DEVIATION REQUEST AND DECISION FORM

Project Name : Sterling Ranch Sand Creek Channel Construction Drawing Review CDR 20-4
 Schedule No.(s) : 5227301021, 5233309027, 5228000030 & 38, 5233301001 5233301016 &17
 Legal Description : See Exhibit B – Legal Description

A deviation from the standards of or in Section **ECM section 3.3.3 Open Channel Design Standards** of the Engineering Criteria Manual (ECM) is requested for the Sand Creek Channel Design – Channel Perimeter Fencing.

Exhibit A
Fencing Detail

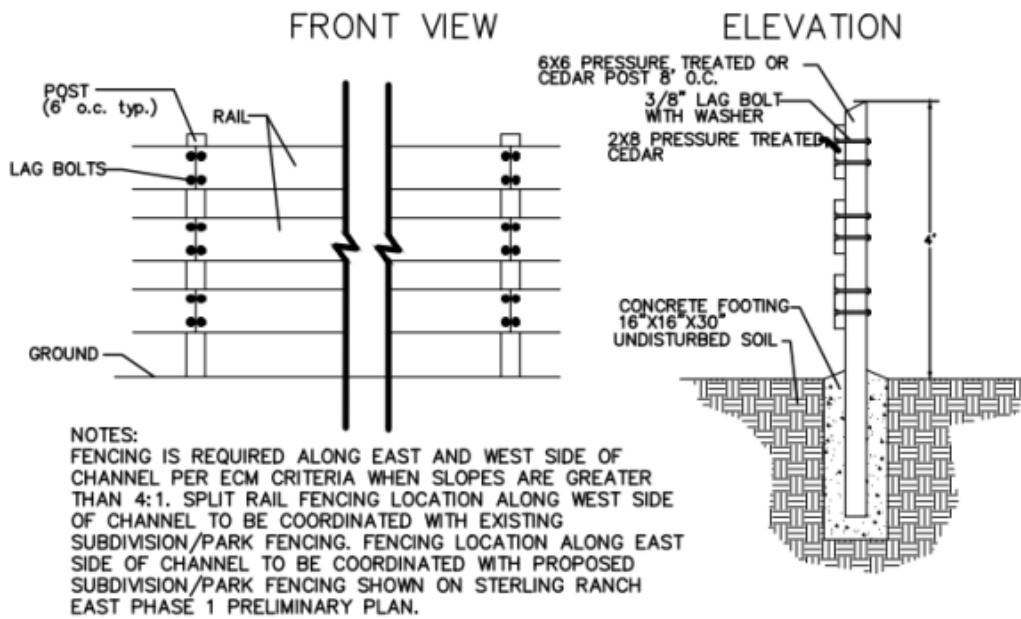
Address why fencing would be needed (steeper than 4:1 slopes) and where the channel depth and velocity factor applies, would pedestrian safety be a concern? State that ADA requirements will be met where applicable.

Please provide a cross-section and detail of the proposed fencing and plans showing the locations and adjacent grades

CHANNEL FENCING EXHIBIT
 SAND CREEK RESTORATION
 JOB NO. 25188.04
 10/19/23
 SHEET 1 OF 1

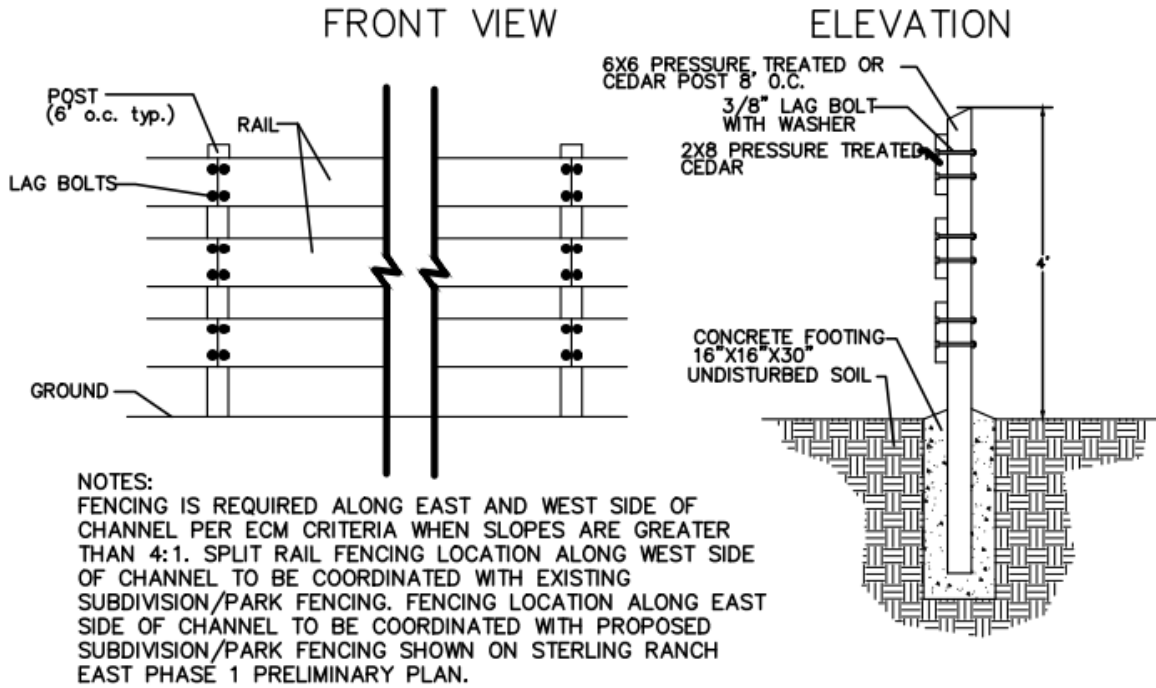
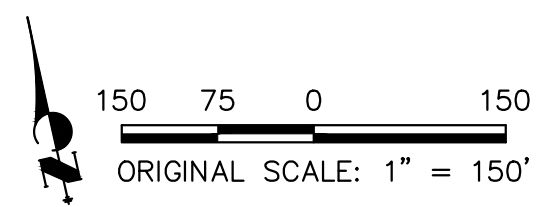
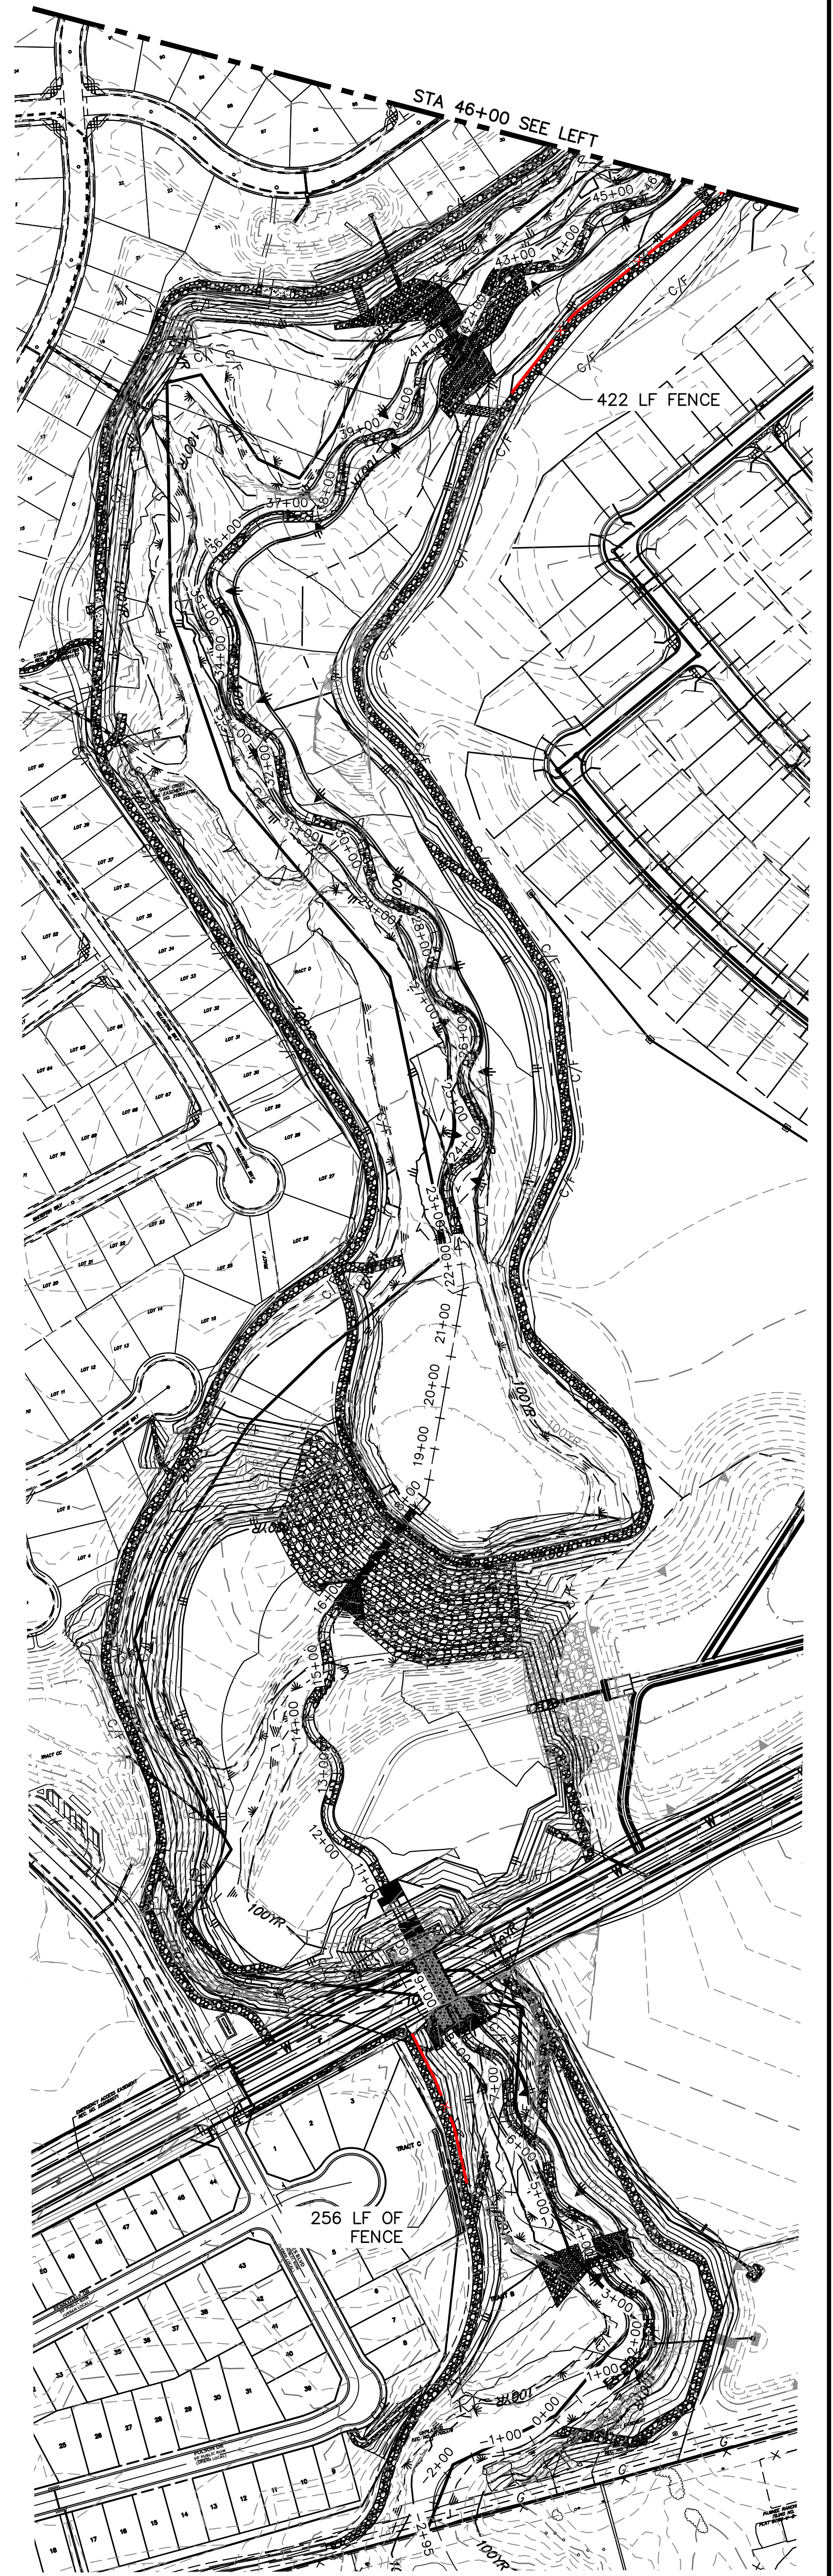
Will district maintain the fencing? Provide overall map showing where requested County maintenance areas would be.
